Re: P-07-31

Thank you for the opportunity to comment during the optional determination of nonsignificance process for the Palomino Fields preliminary subdivision revision, proposed by Cle Elum Pines East, LLC. We have reviewed the documents and have the following comments.

**RE: DA-15-00001 Development Agreement Phase Recommendation**

**SUBJECT: Palomino Fields Development Agreement (P-07-31) surrounding Currier Creek – Proposal to Construct in Five Phases**

Phasing Plan

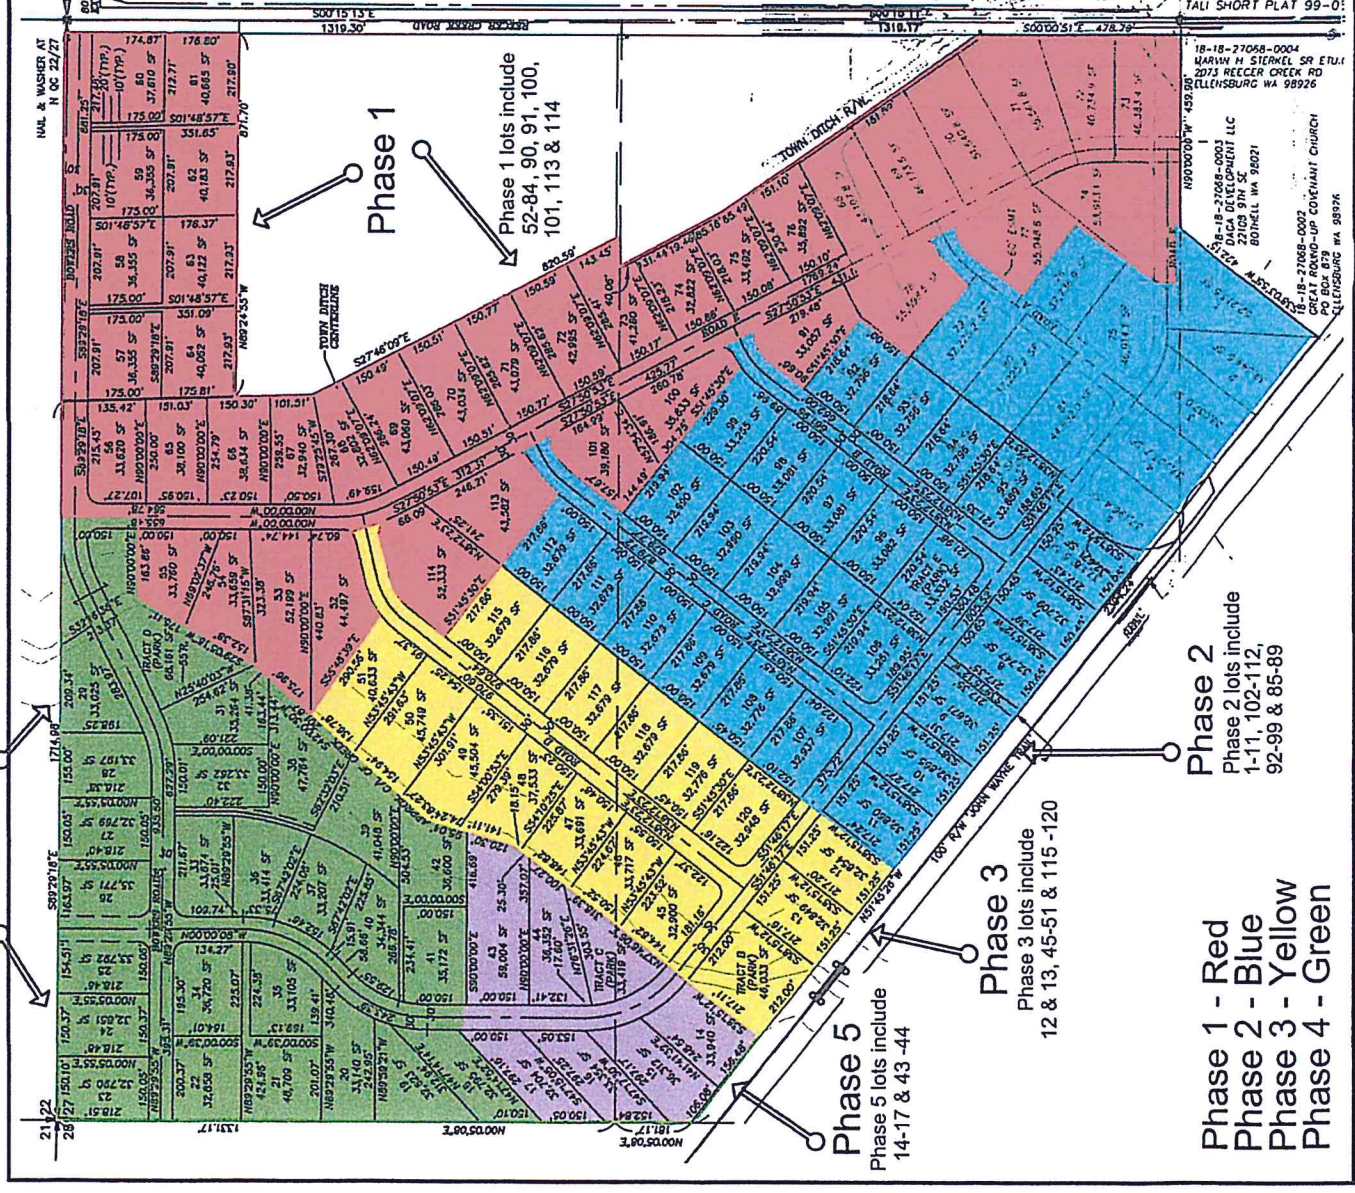
We do not have detailed phasing plans for this project, but our interest is in ensuring the fish and wildlife habitat associated with Currier Creek is incorporated into the planning/phasing and that the creek, its buffer, and the floodplain are protected to the greatest extent possible. As such, we have the following recommendations for inclusion in Phase 1 to protect fish and wildlife habitat:

- All utilities, including septic plans, should be properly laid out and planned in Phase 1.
- The four wetlands referred to in the 2008 Hearing Examiner's findings should be clearly identified on the plans along with their buffers to ensure their protection.

- The 100 foot buffer from the top of bank on each side of Currier Creek should be clearly identified on all plans and in the field to ensure its protection and to prevent encroachment into the buffer.

- All drainage features for stormwater and flood water should be planned and installed as part of Phase 1. The aerial photos in the attachment demonstrate that much of this development is within an active floodplain.

- We note that most of the parks are located within the 100 foot buffer for Currier Creek. Please provide plans for these parks, demonstrating that the functions of the buffer will not be impacted by development or actions in the parks.
